CITY OF ALBUQUERQUE

May 6, 2022

Re: Caterpillar Clubhouse
803 2nd St. SW
Traffic Circulation Layout
Architect's Stamp xx-xx-xx (K14-D227)

Based upon the information provided in your submittal received 04-27-22, the above referenced plan cannot be approved for Building Permit until the following comments are addressed:

A3 ENLARGED RAMP DETAIL

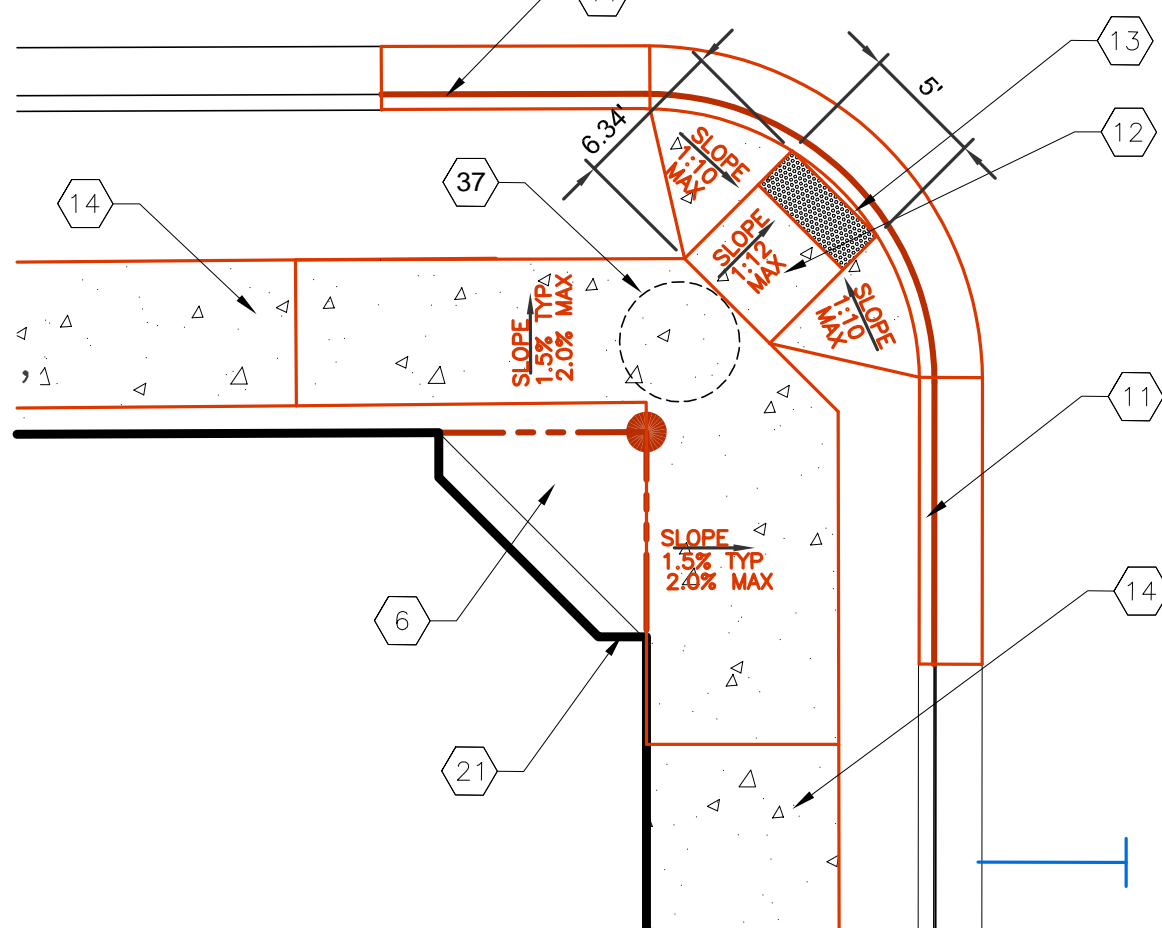
1. The traffic circulation layout must be stamped, signed, and dated by an engineer or architect licensed in the state of New Mexico.
2. Please see attached revised ADA ramp at the corner of 2ND St. and Hazeldine Ave. Remove the blue flared sides and keep the green flared sides to avoid a tripping hazard. Please note that flared side are to have a slope of 10% max. Also, provide 5'X5' landing area with 2% max. slope, ramp dimensions, and sidewalk easement as needed.

A1 TRAFFIC CIRCULATION LAYOUT

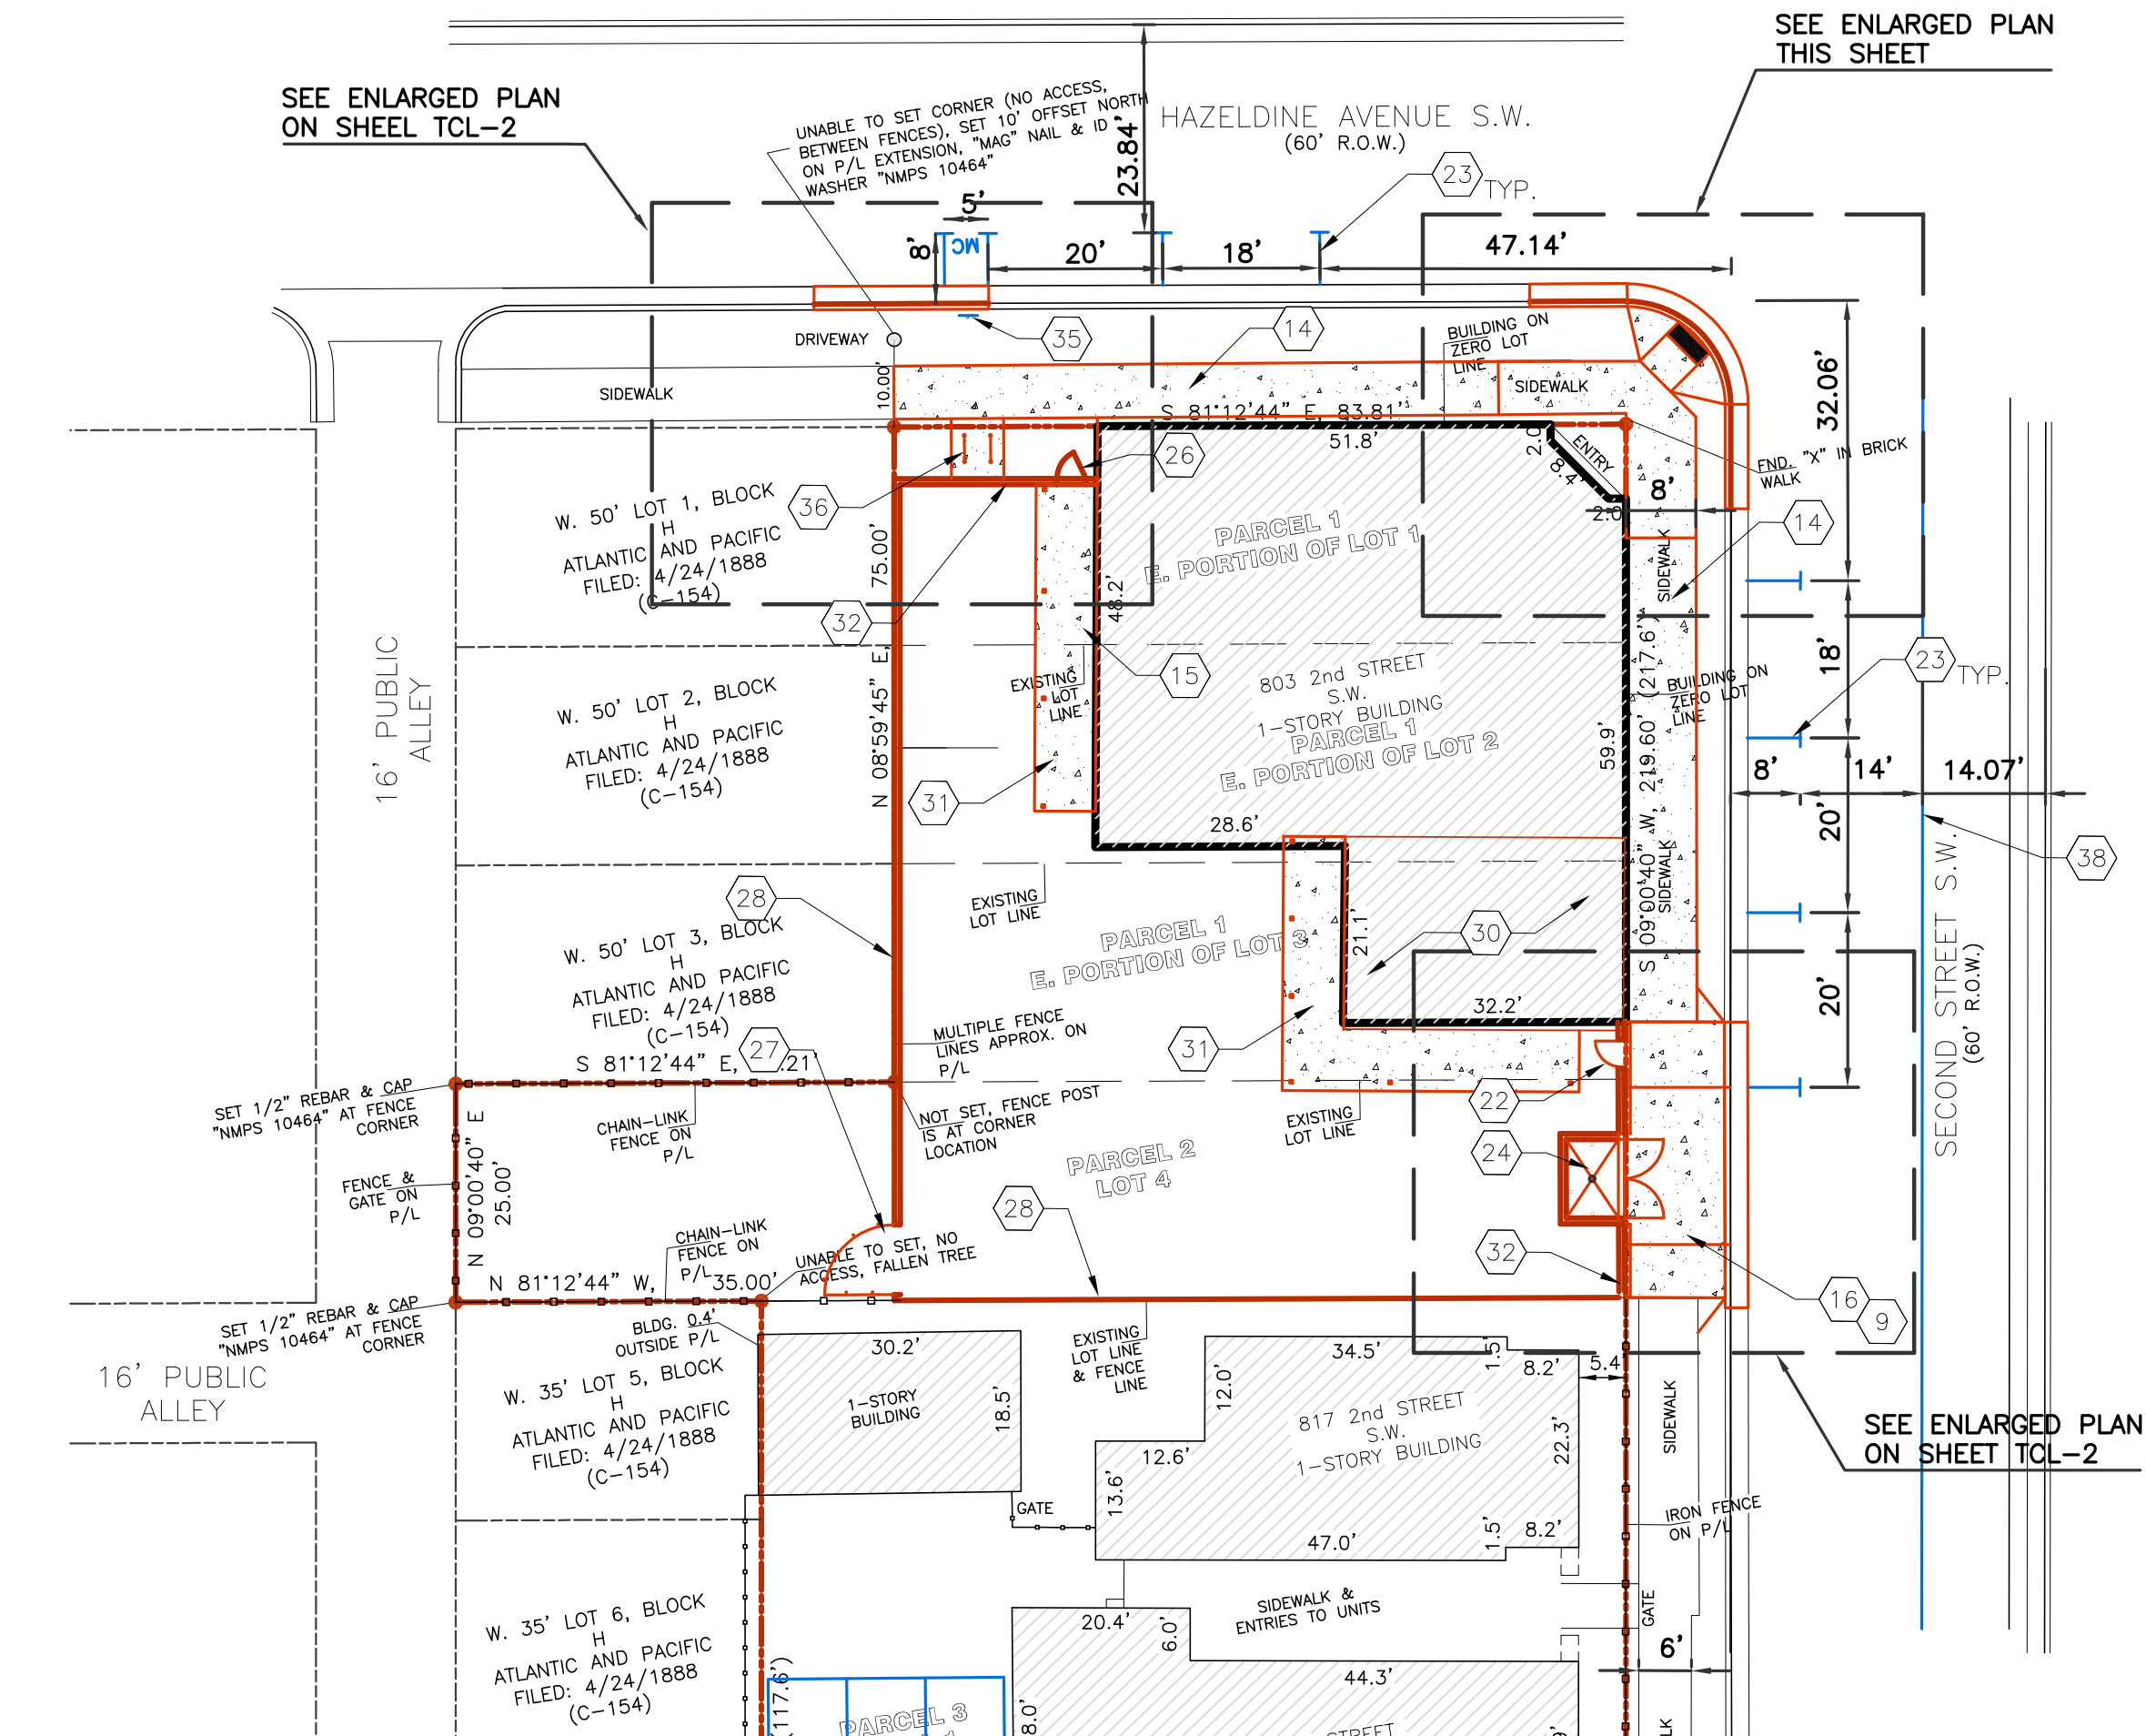
3. Provide the 2nd St. driving Lane's width and Hazeldine Ave. Lane's width. To determine if there are adequate spaces for on-street parking.
4. Show on site plan 6' ADA pathway from ADA aisle (for the new ADA parking) to the building entrance.

5. Provide parking requirement calculation for Parcel 4 Lot A-2 showing that they have adequate parking spaces for shared parking spaces. And how there parking spaces are applicable.

6. Please relocate the ADA parking space to Lot 4 (IF APPLICABLE). Transportation is OKAY with ADA parking off Alleyway.
7. The ADA access aisles shall have the words **"NO PARKING"** in capital letters, each of which shall be at least one foot high and at least two inches wide, placed at the rear of the parking space so as to be close to where an adjacent vehicle's rear tire would be placed. (66-1-4.1.B NMSA 1978)

10. It is not apparent what type of pavement surface is being proposed. A hard driving surface will be required as part of this proposed project for parking area and drive aisles.
